SAFETY AUDIT

STAGE 1/2

Wadsworth Gardens PROWs, Cleckheaton

ON BEHALF OF
BARRATT & DAVID WILSON HOMES

TITLE: **S38 PHASE 2 PROPOSED SURFACE FINISHES & KERBING SHEET 1 OF 2**

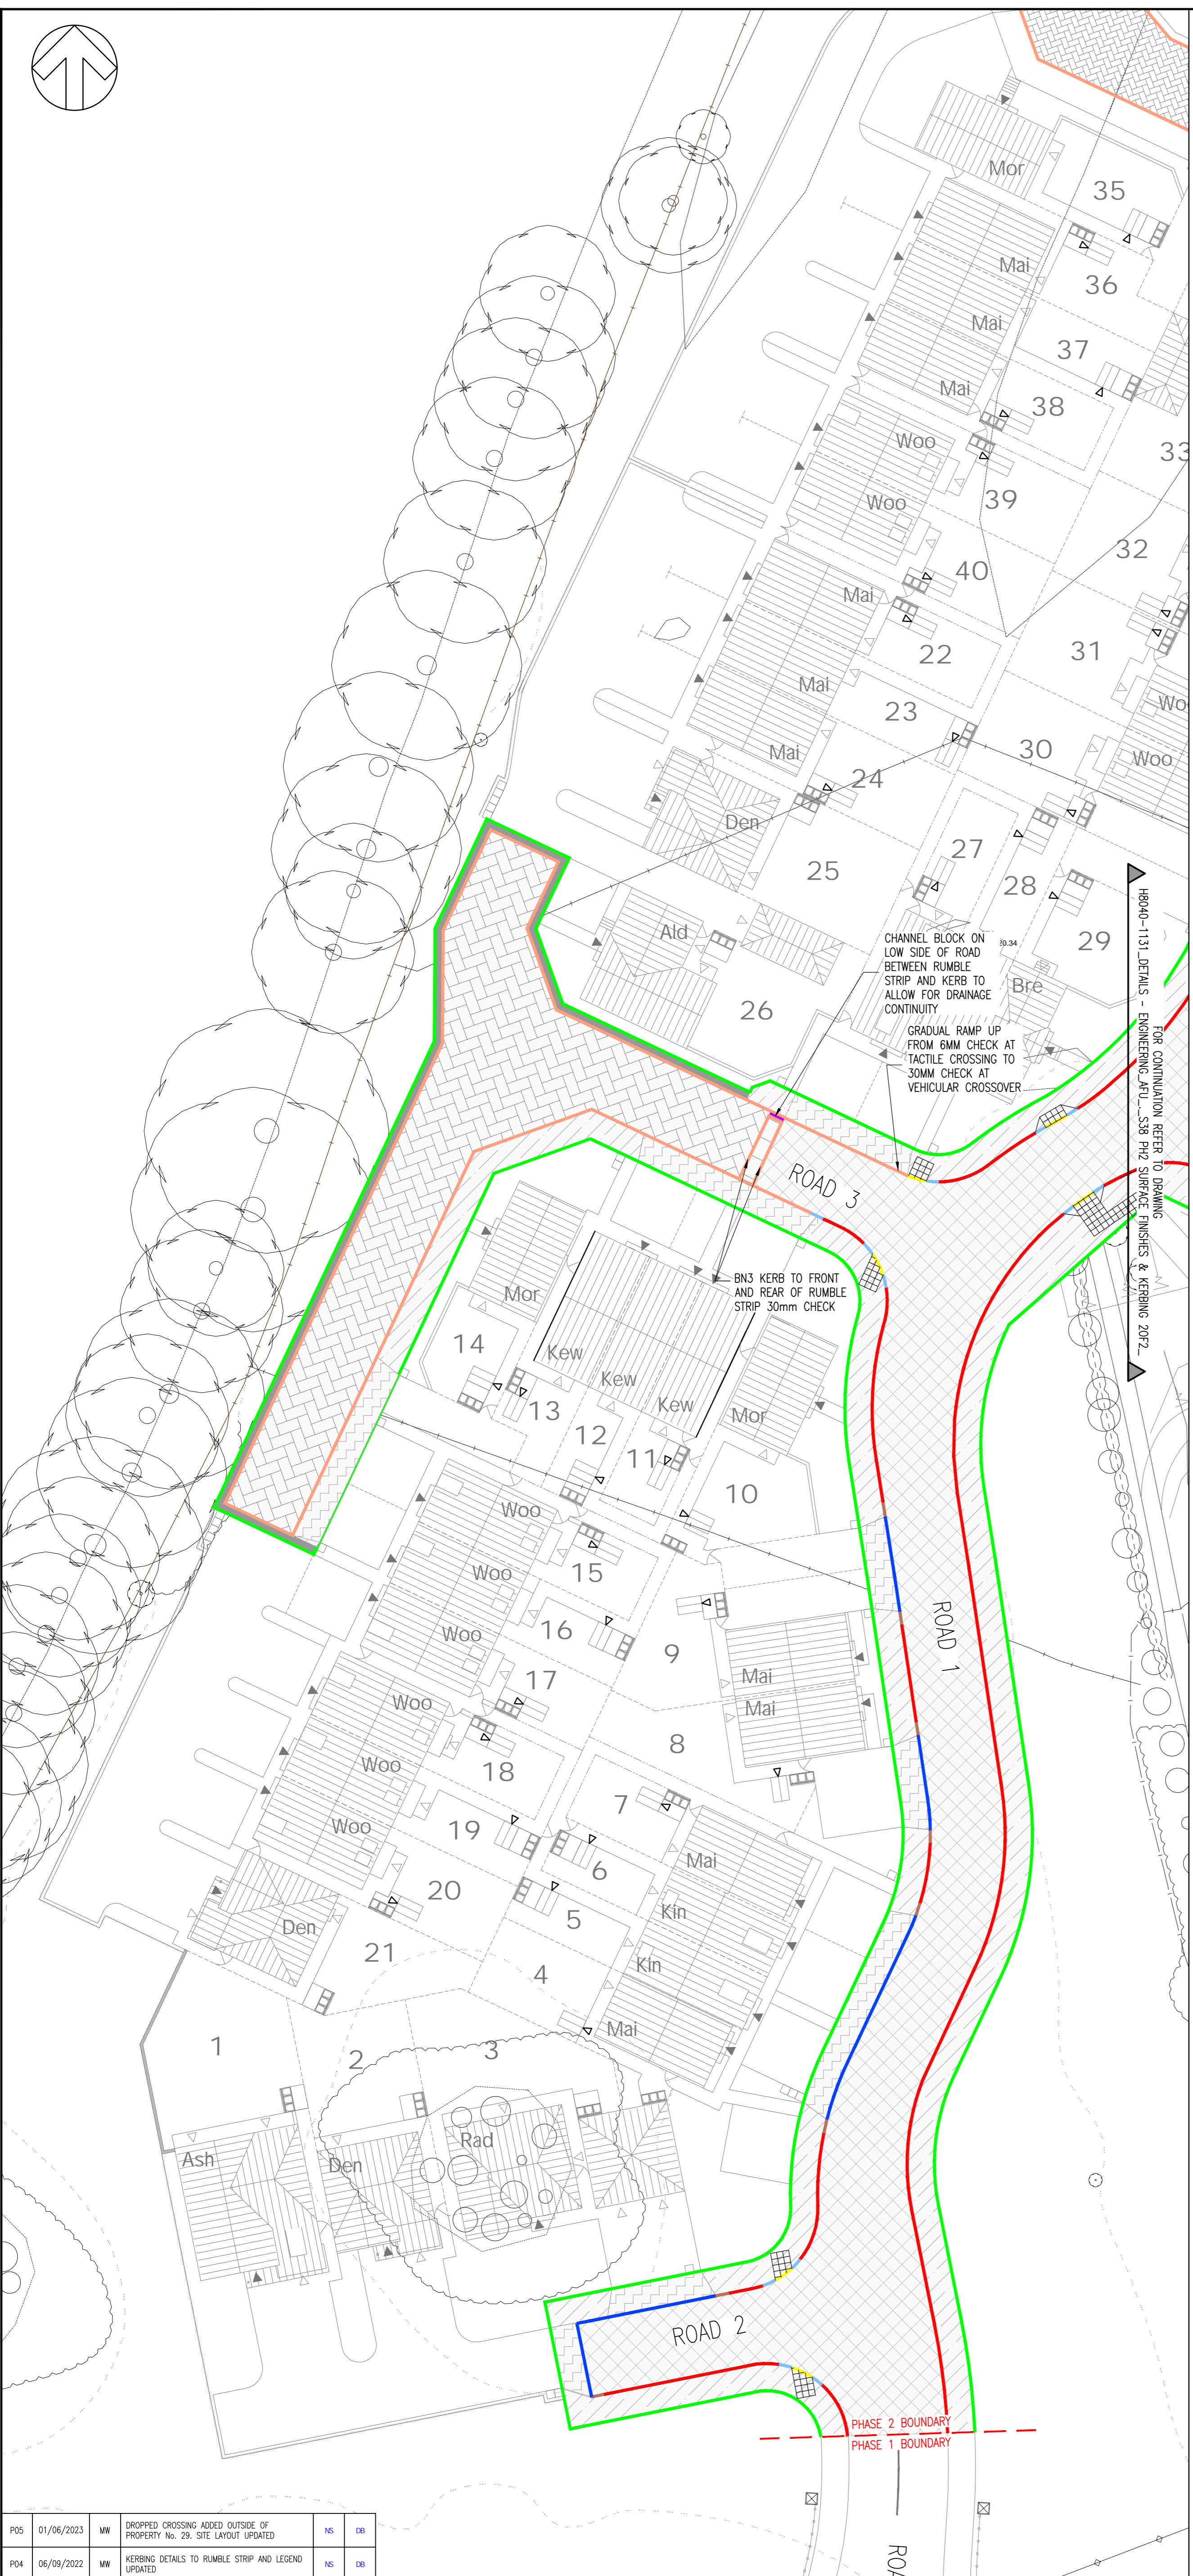
The drawings provided show that the proposed dropped crossings / tactile paving located adjacent to the top of the steps on the PROW opposite plots 28 / 29 are offset from the direct line of the route for pedestrians emerging from the top of the steps. No explanation for this offset has been provided.

The location of this crossing point on a tight bend is not readily apparent to approaching drivers and the latter might be taken by surprise if say a group of walkers suddenly emerged from the steps and needed to cross the road.

It is recommended that the drawings be amended to revise the position of the dropped crossings / tactile paving to be in line with the proposed route. The presence of the crossing point is recommended to be highlighted by either the provision of a different colour / texture of road surface and / or placed on a flat top speed hump.

REVISION			
DRAWING TITLE			
PROW FINISHES PLAN			
PROJECT:			
RESIDENTIAL DEVELOPMENT			
PROJECT ADDRESS:			
WHITECHAPEL ROAD CLECKHEATON			
DRAWN	SCALE	DATE	
AJC	1:250 @ A0	NOV 2021	
DATE	DWG. NO.	REVISION

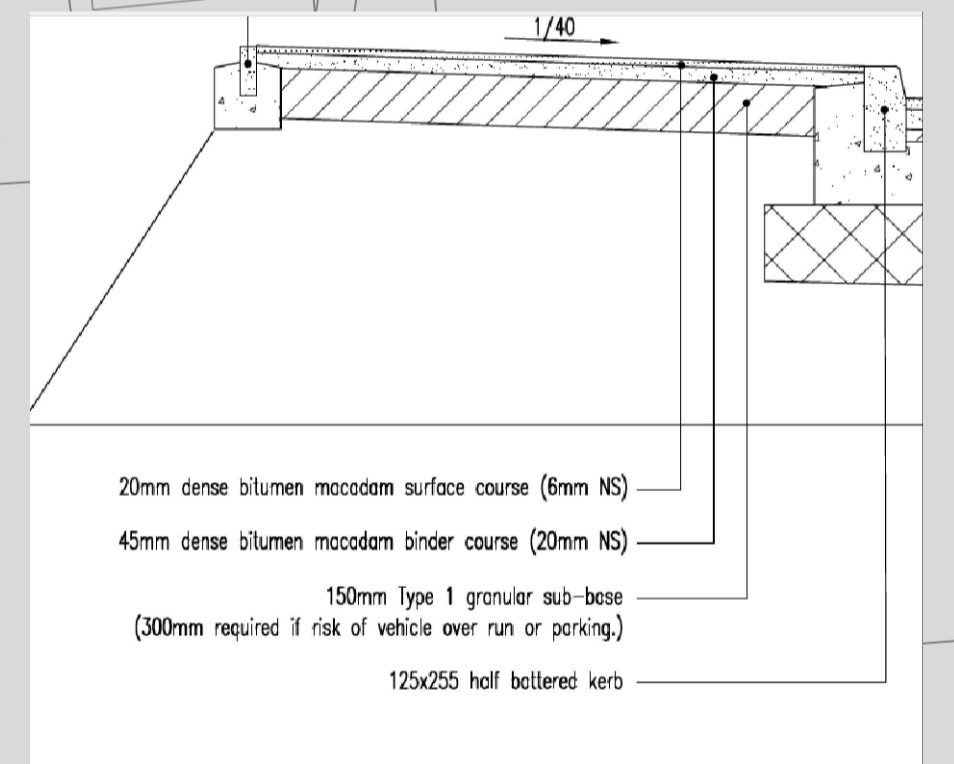
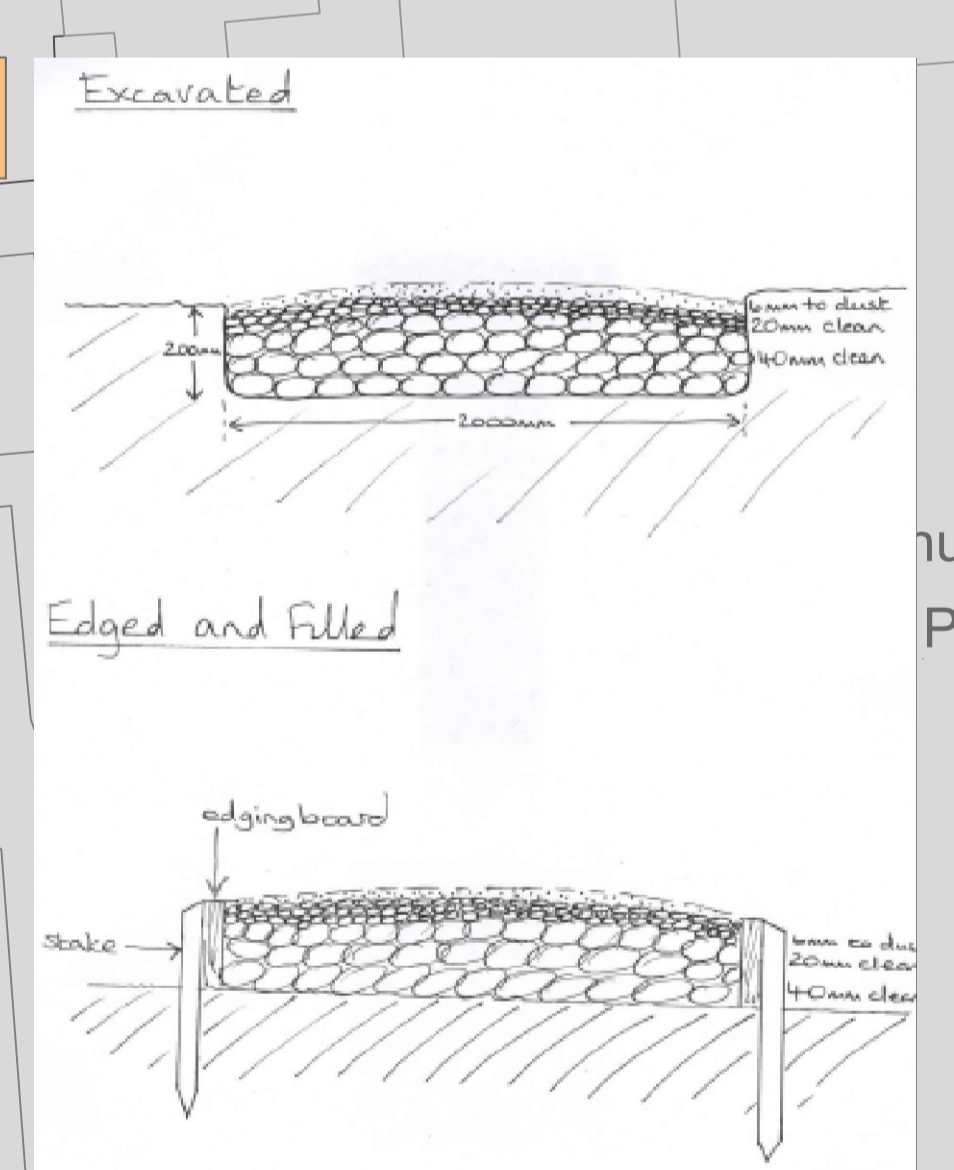
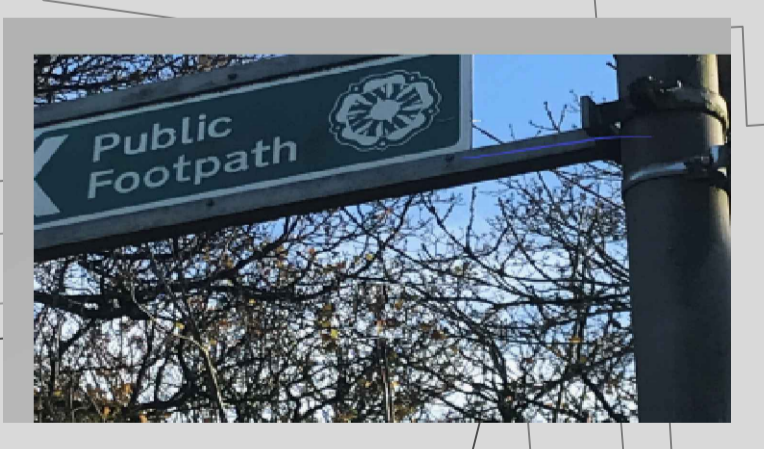
The drawings show that the PROW in the above location would be to a loose stone footpath specification. As this will be overrun by maintenance vehicles, over a period of time this construction might fail and so create trip hazards for users.

It is recommended that the specification for the PROW in the above location be upgraded so as to cater for overrun by maintenance vehicles.
